DRB Application No.: 08DRB-70089 Project # 1001562  
Project Name: RESERVE AT FOUR HILLS SUBDIVISION  
Agent: MARK GOODWIN AND ASSOCIATES Phone No.: 828-2200

**Project# 1001562**  
08DRB-70071 VACATION OF PUBLIC EASEMENT

MARK GOODWIN AND ASSOCIATES PA agent(s) for PULTE HOMES OF NEW MEXICO INC request(s) the above/ referenced action for the Temporary Drainage Easement on Tract A, Block 1, **RESERVE AT FOUR HILLS SUBDIVISION**, zoned R-1, located on SEA BISCUIT DR SE BETWEEN SECRETARIAT AV SE AND SEATTLE SLEW AVE SE containing approximately 0.7208 acre(s). (M-22)

PLAT FOR
**LOTS 11-P1, 12-P1, 13-P1 &
 TRACT A-1, BLOCK 1**
 RESERVE AT FOUR HILLS SUBDIVISION
 WITHIN SECTION 34, TOWNSHIP 10 NORTH,
 RANGE 3 EAST, NMPM
 CITY OF ALBUQUERQUE
 BERNALILLO COUNTY, NEW MEXICO
 FEBUARY 2008

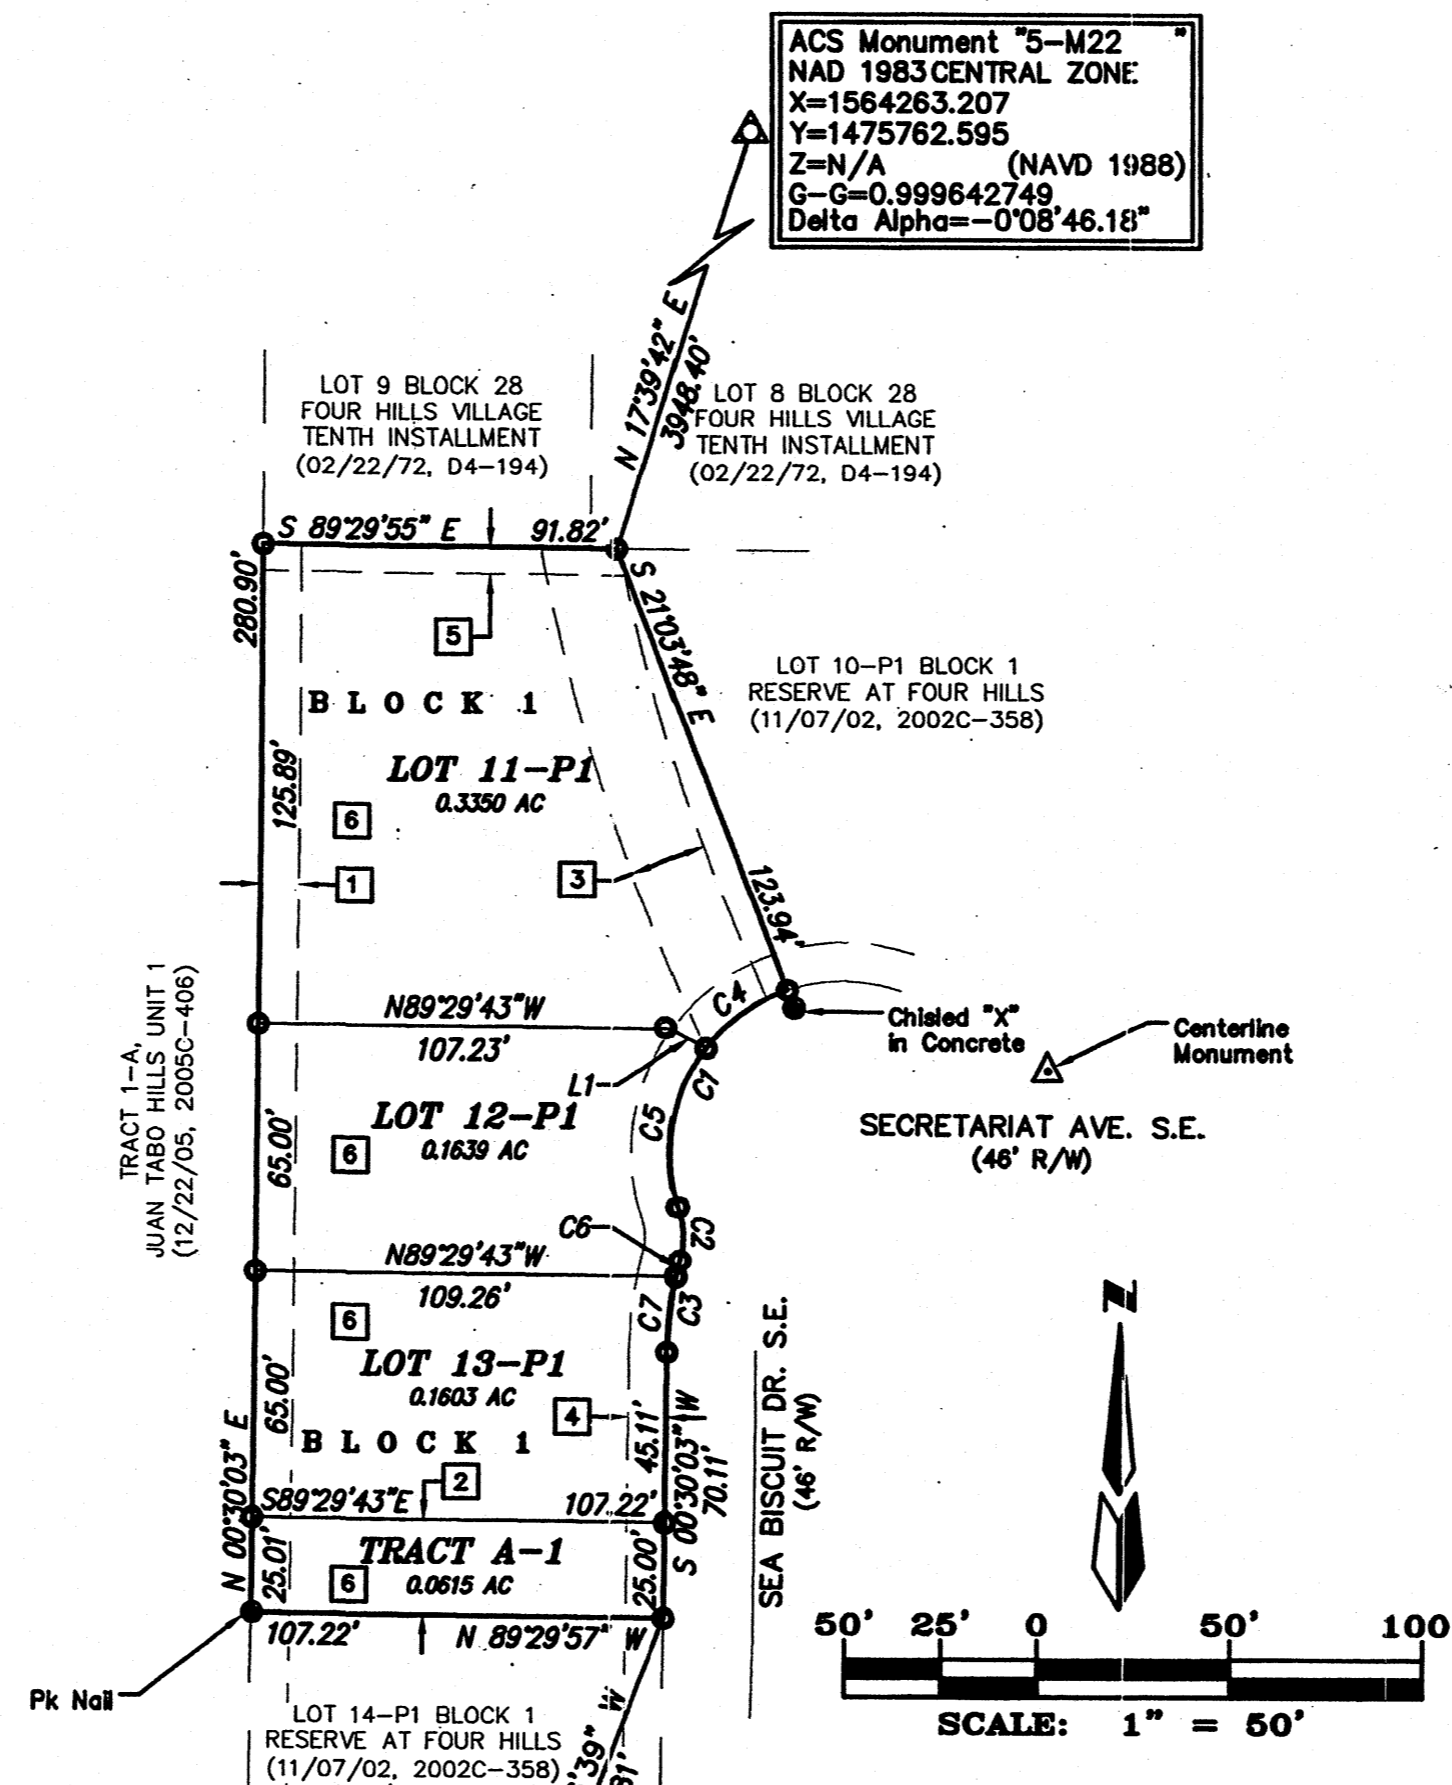
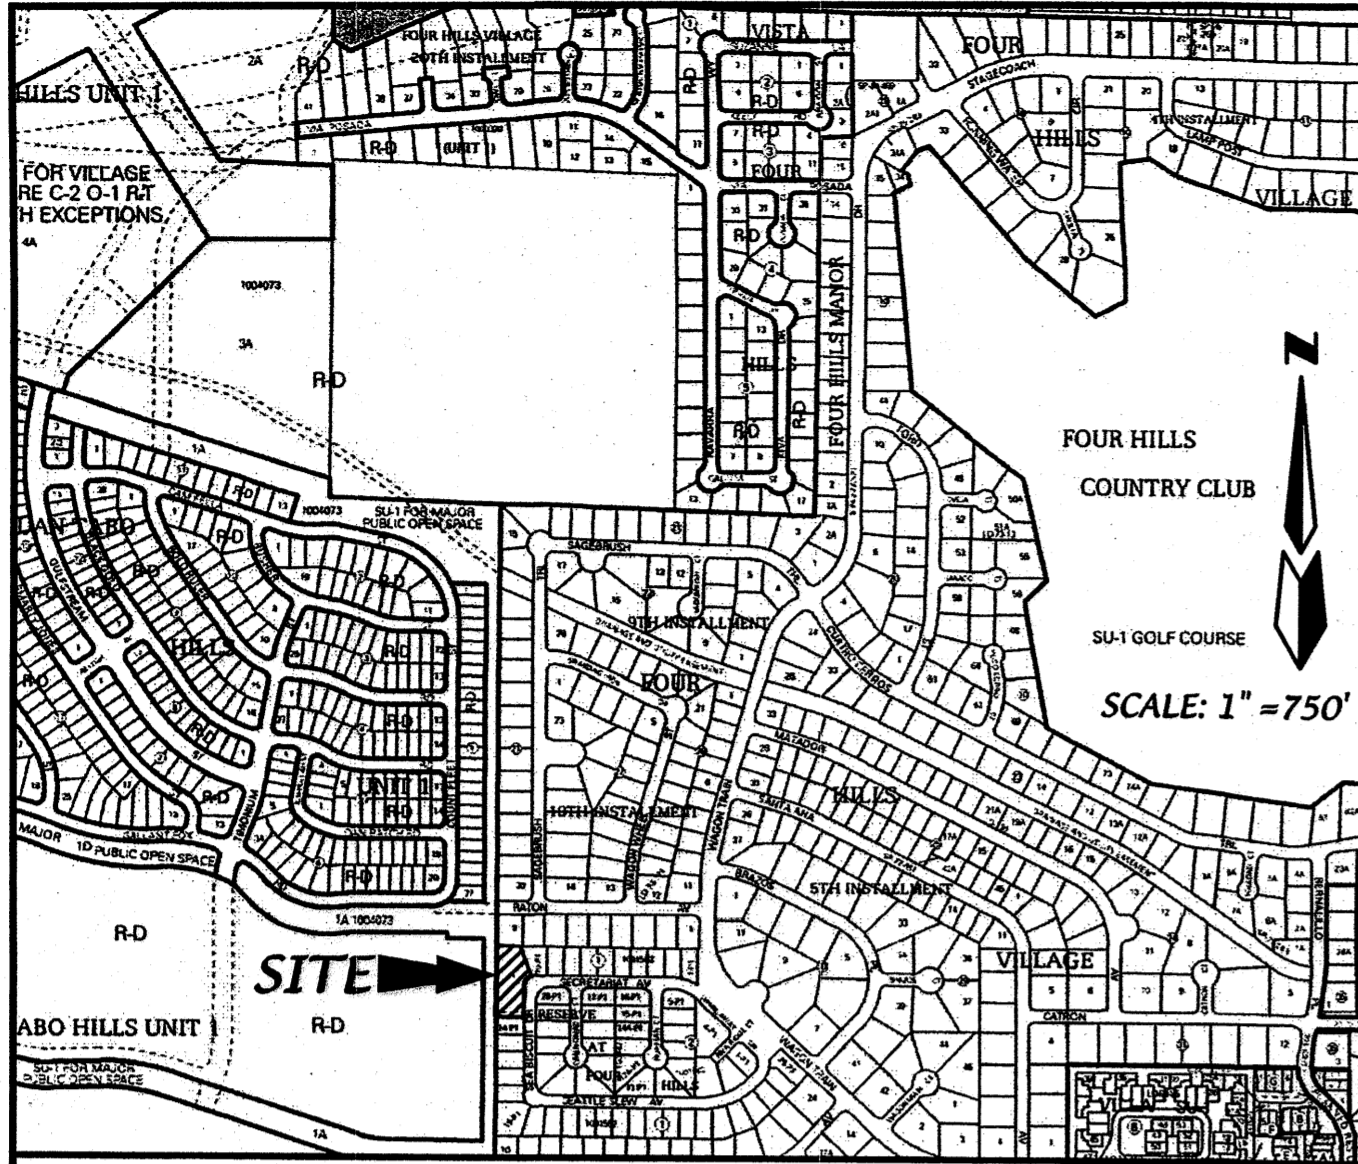
PLANNING (Last to sign): - exhibit to verify DW  
~~to be shown on ground DW easement~~  
KRISTAL HAS INFO AND APPROVED

PLANNING (Last to sign): - exhibit to verify JW  
15 in R.O.W., or grant JW easement  
\_\_\_\_\_

The preliminary plat was approved with final sign off delegated to City Engineer for certification of Grading Plan on the plat, and to Planning for Exhibit indicating location of sidewalk and distance of face of curb to property line, and to record.

A vacation exhibit is not provided.
